Gatwick Airport Northern Runway Project

Environmental Statement

Appendix 9.3.3: Summary of Stakeholder PEIR – Ecology

Application Document Ref: 5.3

Title
Surface Access Highways Plans
Structure Section Drawings
APFP Regulation 5(2)(o)
Sheet 1
A23 Brighton Road Bridge over River Mole

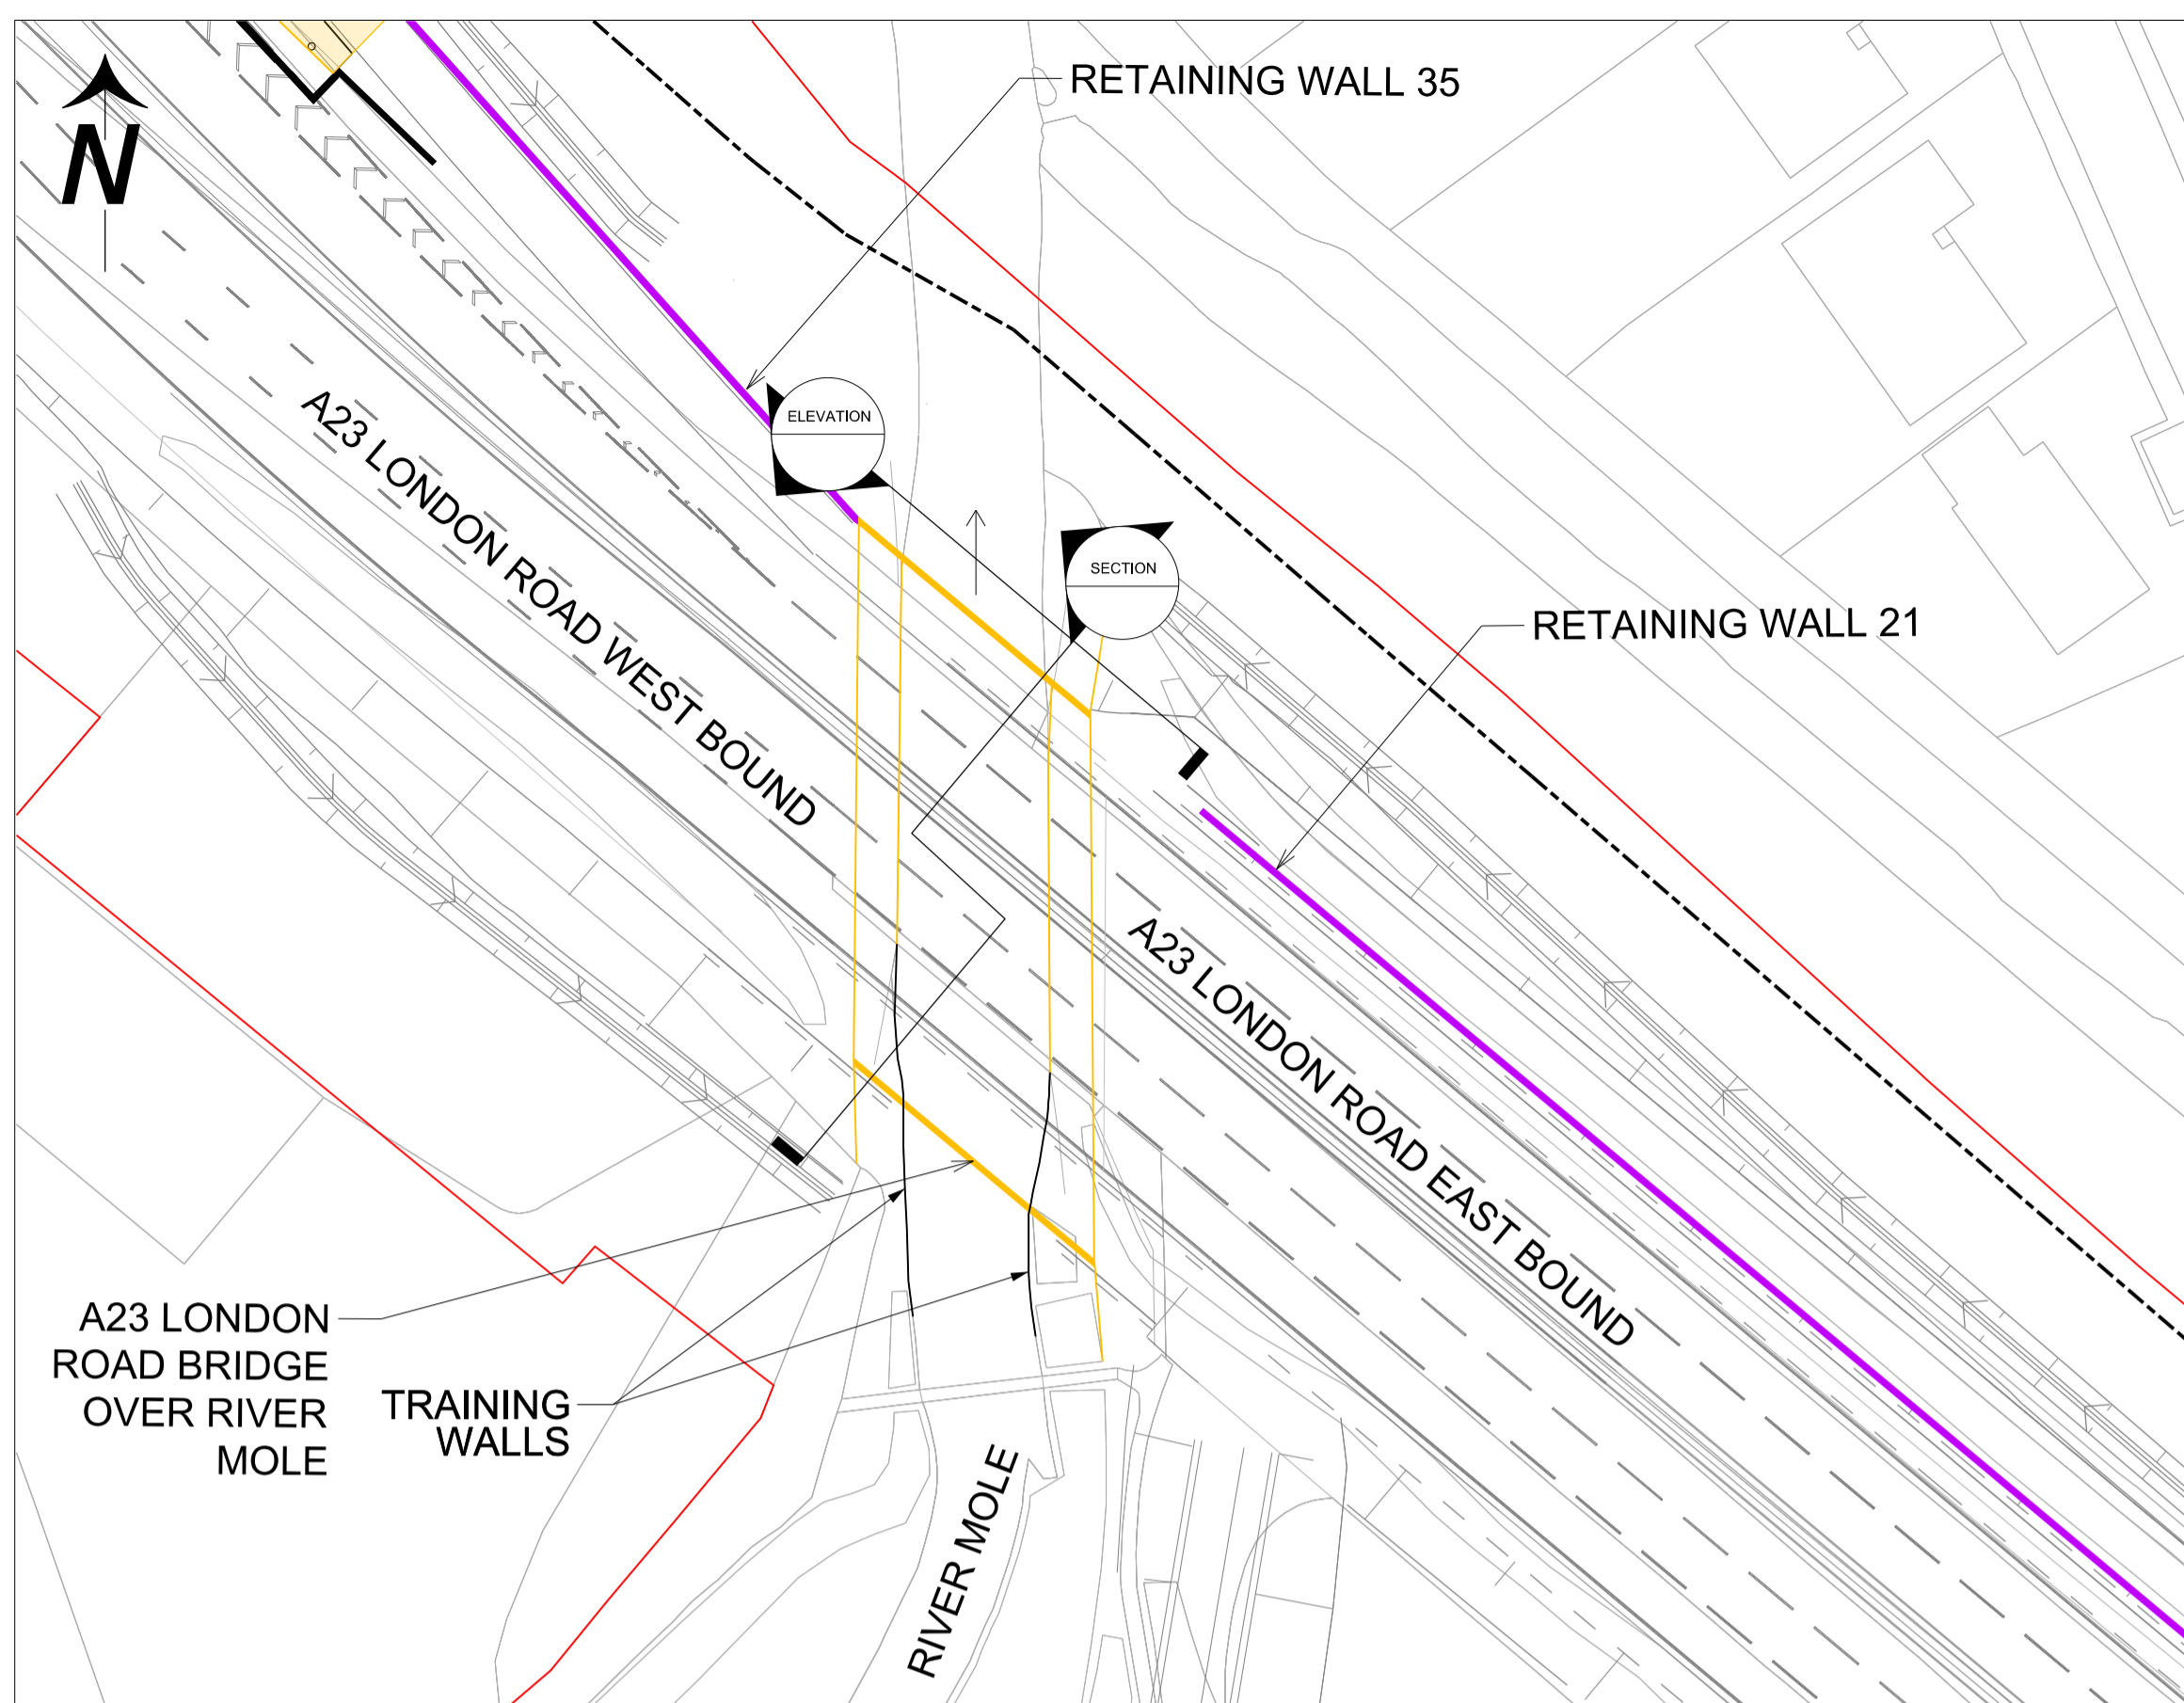
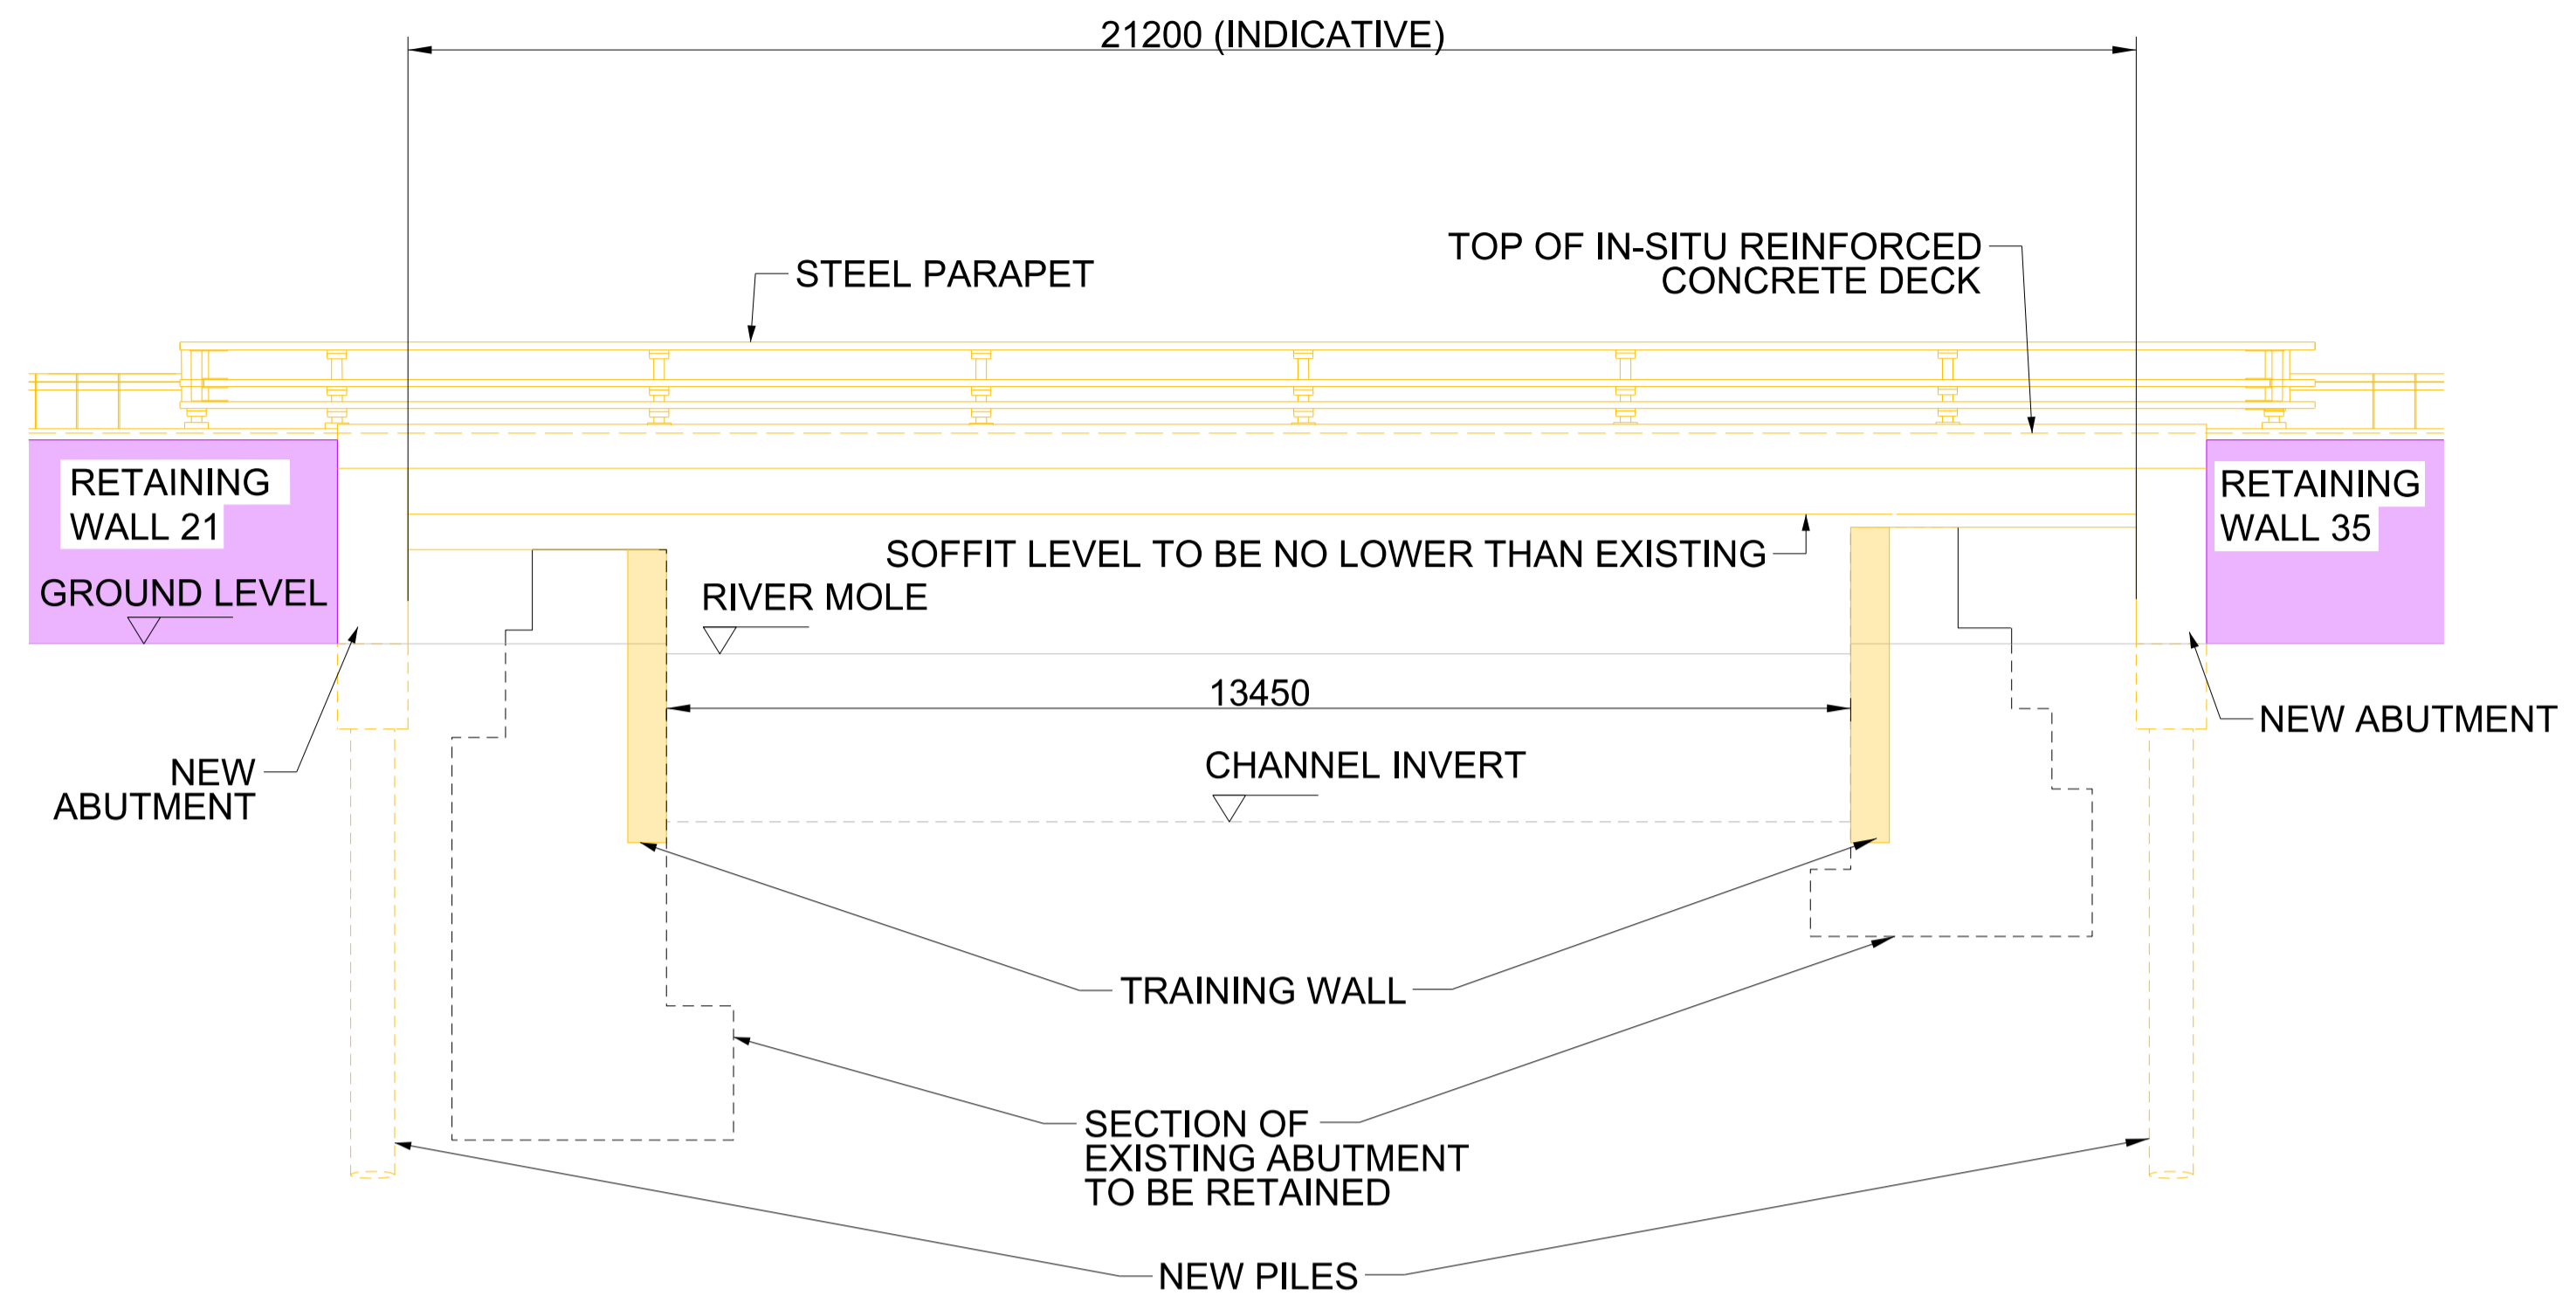
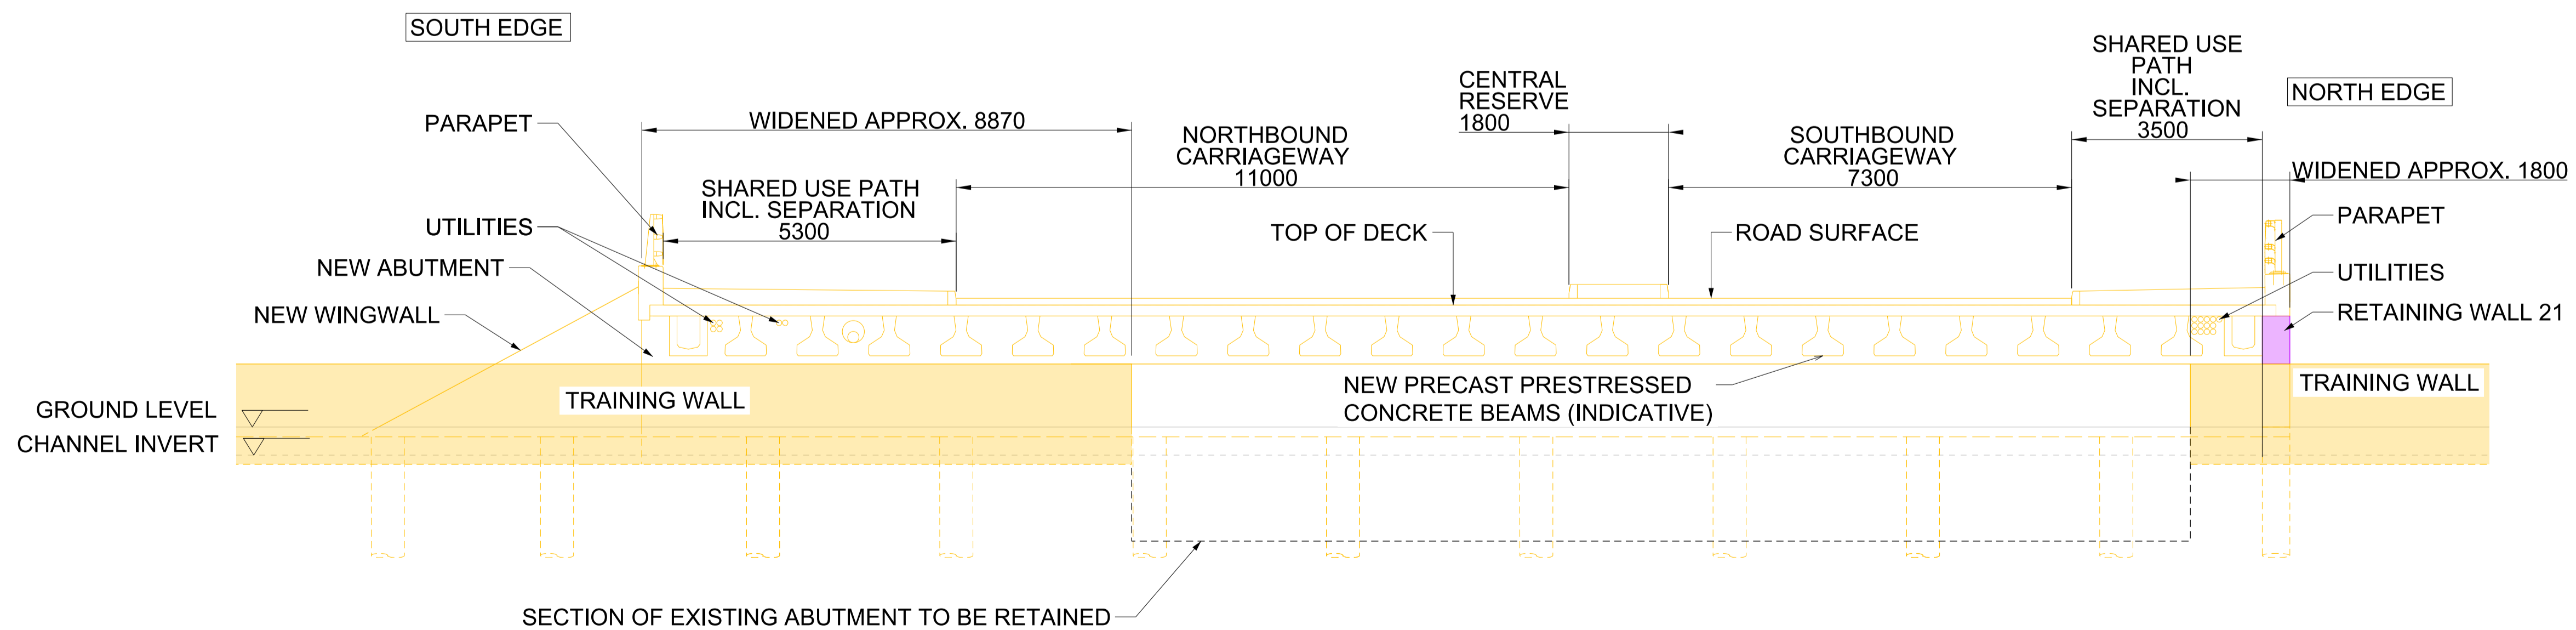
West Sussex County Council	27 July 2022	A23 Brighton Road (7): The new bridge structure crossing the River Mole is likely to be ecologically sensitive and will require very careful consideration and design.	Noted. The assessment of the effects resulting from the surface access improvements is included in Section 9.9 (Chapter 9 of the ES).
West Sussex County Council	27 July 2022	It is apparent that further extensive vegetation loss is proposed as stated in the consultation document at various points and particularly in table 3.1.2, which analyses the significant effects on landscape, townscape and visual resources compared to the PEIR. Concern is drawn for example to the M23 spur, where new significant effects that would be major adverse in the long term has been assessed. The hedgerow and mature oak trees that define the field boundary immediately north of the Sussex Border Path would also be removed to accommodate the temporary construction works, resulting in the loss of an important landscape feature. It seems completely disproportionate that a mature, important landscape feature like this should be lost permanently for temporary works, and further justification for this should be given. If there is no alternative to their removal, the trees should be replaced on a 2:1 basis. Other areas of concern for this vegetation loss include:: <ul style="list-style-type: none"> South Terminal: new significant effect that would be moderate to adverse in the long term – removing mature vegetation; A23 London Road: the Riverside Garden Park would be impacted by permanent vegetation removal at various widths: 8m, 9m and 13m in width; Longbridge Roundabout - greater extent of vegetation removal required, up to 45m width. 	<p>All vegetation loss will be limited where possible through the design process.</p> <p>Maintaining east-west connectivity will be a key objective of mitigation, in particular along the Gatwick Stream where it arrives close to the A23.</p> <p>Vegetation loss will be compensated for through new planting either within the road corridor, where possible, or elsewhere within the scheme.</p> <p>With respect to BNG, the Project as a whole includes extensive new habitat creation that will contribute to BNG. The approach to BNG is set out in ES Appendix 9.9.2: Biodiversity Net Gain Statement (Doc Ref. 5.3).</p>
